**From:** [REDACTED]  
**To:** [Norfolk Boreas](#)  
**Subject:** Norfolk Boreas Project EN010087  
**Date:** 26 March 2020 21:08:49

Dear Planning Inspectorate,

I would like to respond to the applicants comments to my deadline 5 submission. The comments regarding the baseline noise survey explains the repeatable representative background sound level of 28.4dBA was selected as appropriate for receptor SSR2, (which represents Ivy Todd) as it was slightly lower than arithmetic average of 28.4dBA. (actually the same) West End Bradenham, if it had been monitored, would have been equally as low if not lower, and yet they explain the operating substation noise level shall not exceed 35dB 5 minutes or 32dB 15 minutes adjacent to any noise sensitive location. The applicant reinforces this decision by explaining that at ETG meetings, with the Environmental Health Officer at Breckland Council, it was identified that the noise emissions from the operational project substation must not exceed the permitted noise levels of the existing Dudgeon substation, (35dB 5 minutes, 32dB 15 minutes).

**APPENDIX 3: OS MAP SHOWING CHANGE IN LEVELS VP3 (AGENDA ITEM
4 (a) II)**

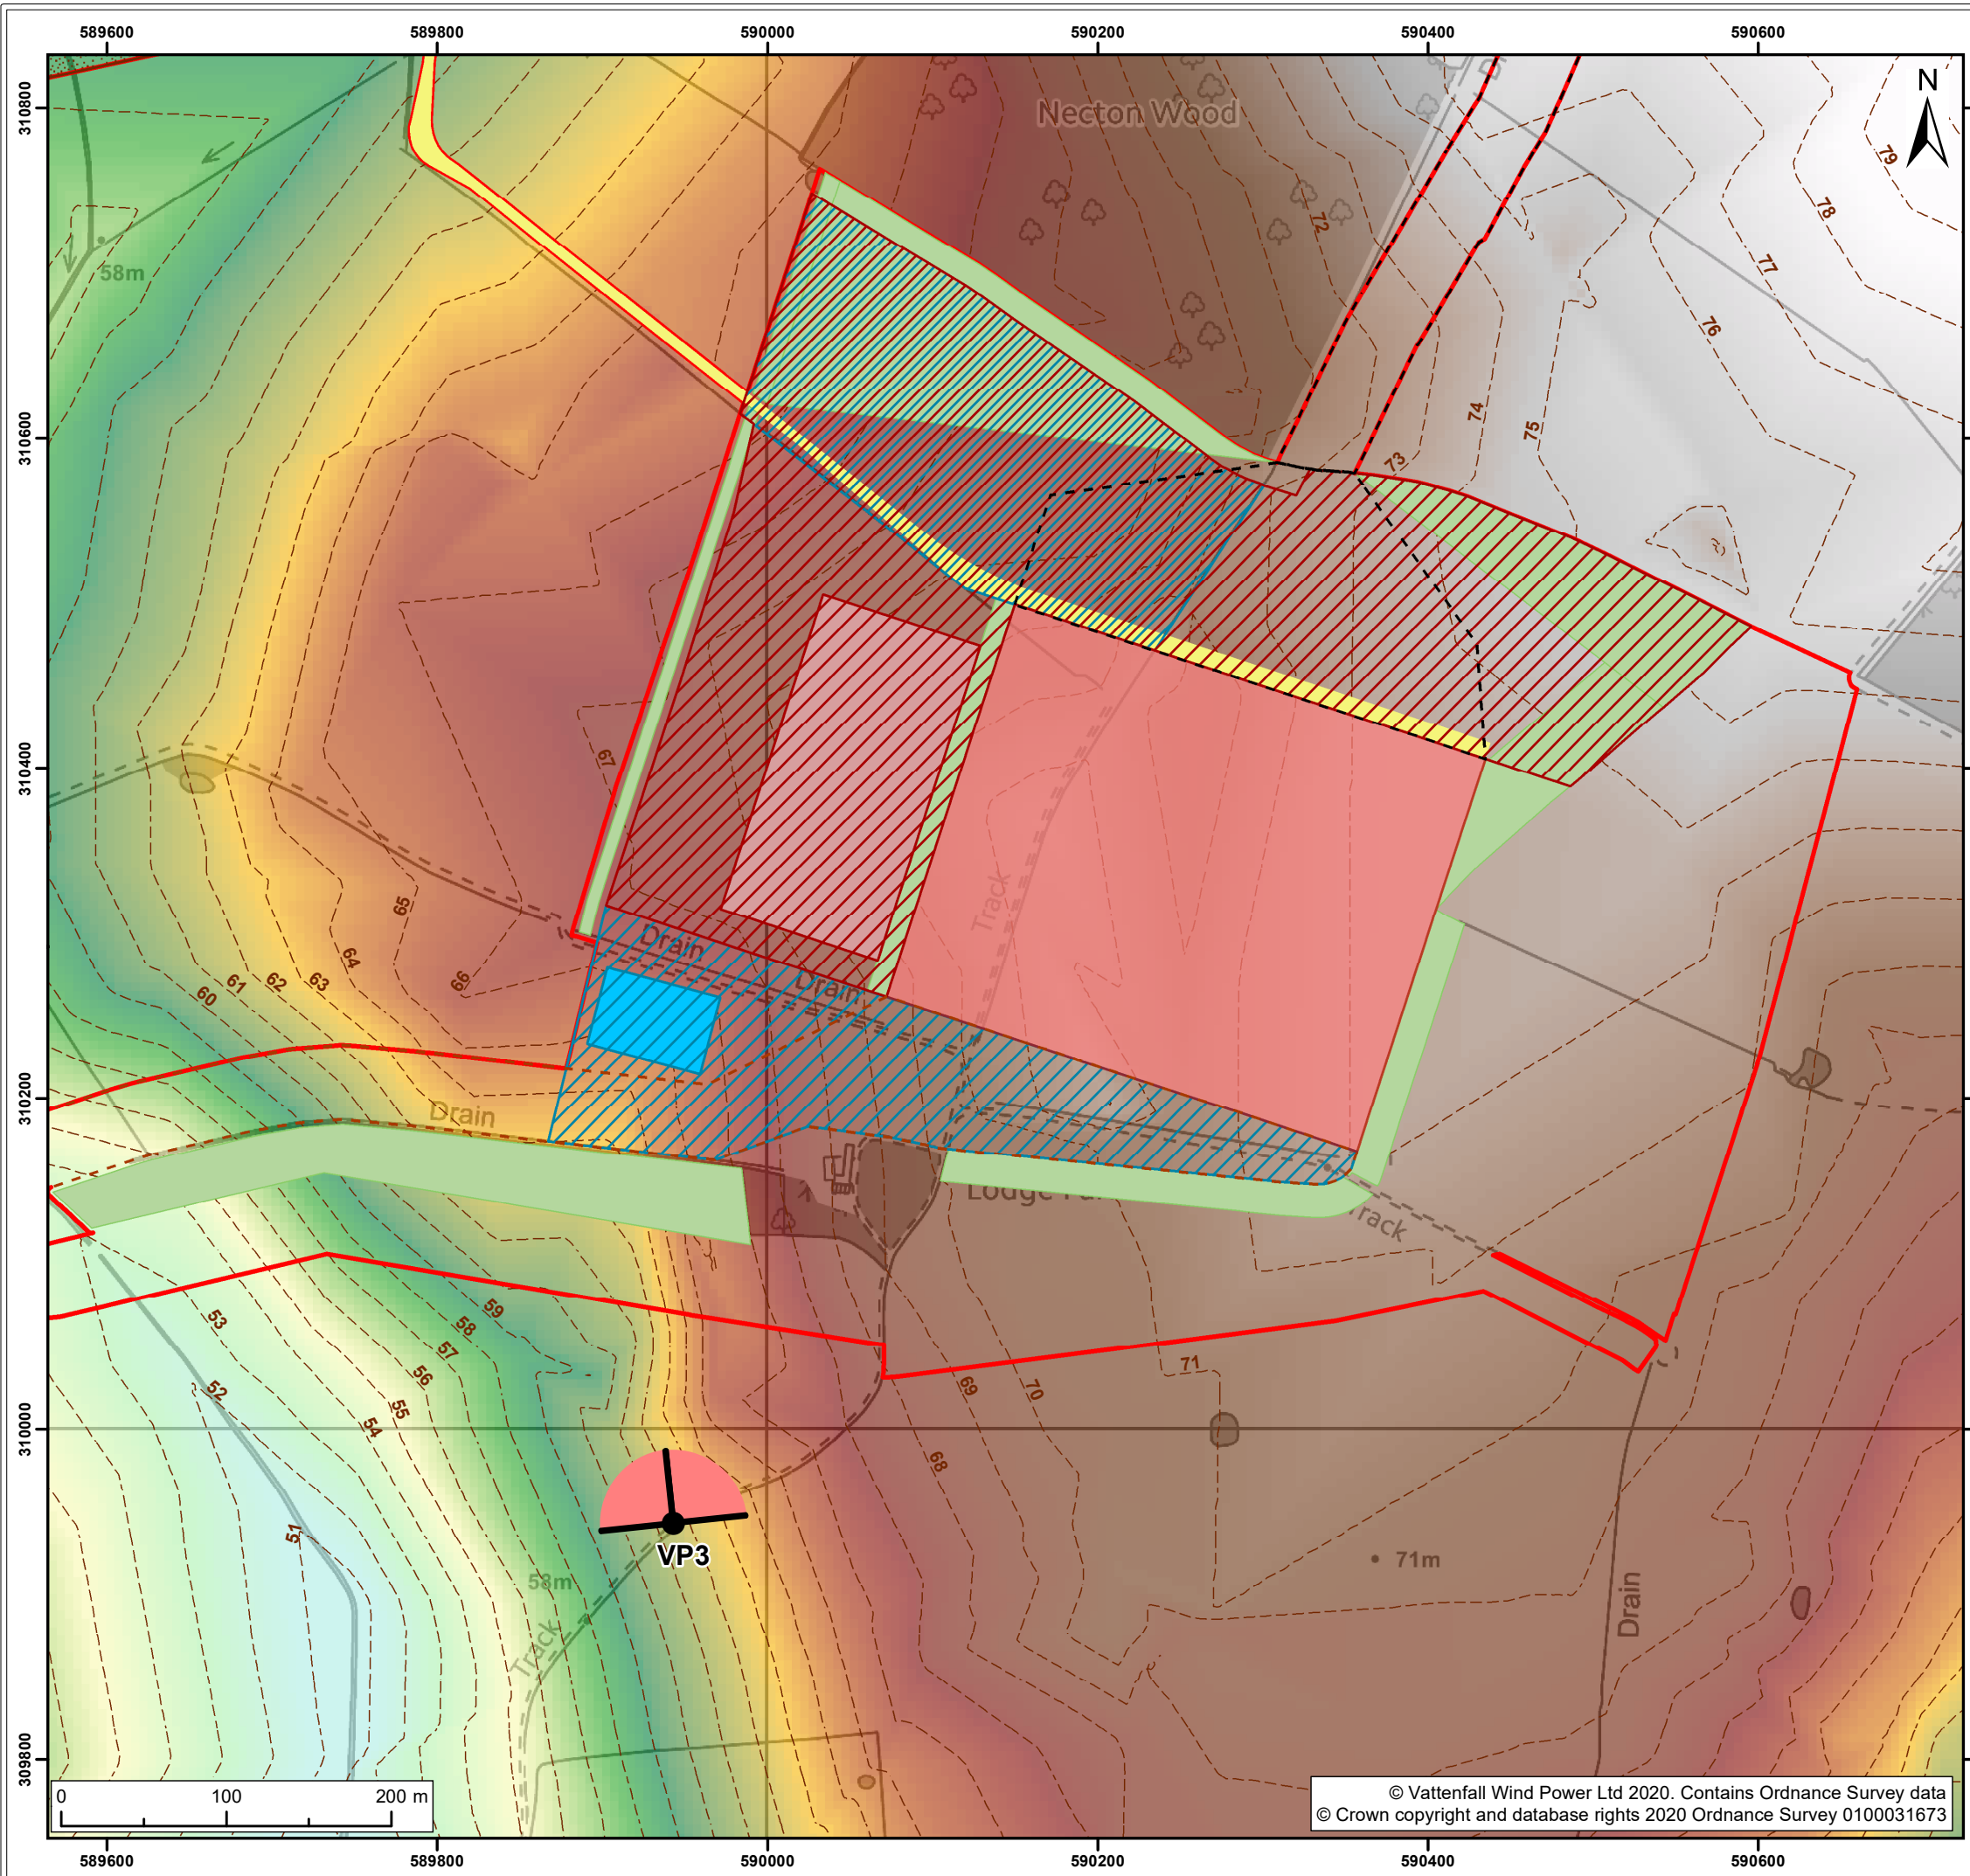
The applicant states the SNH guidelines go on to add, "it is important to stress that visualisations represent just one source of information that forms the LVIA." As far as I am aware, all visual impacts are assessed with the visualisations. There is mention of observations in the field, but no information is provided from these observations, and any information gained from these observations failed to correct the major inaccuracies at

viewpoints 3 and 7.

The explanation of how the photo montages are produced, describes how the substation buildings and infrastructure is generated, and placed, not by vectors and vertices, but by human consideration, with great care, and many on going verifications. This system failed to work satisfactorily for viewpoints 3 and 7, at least.
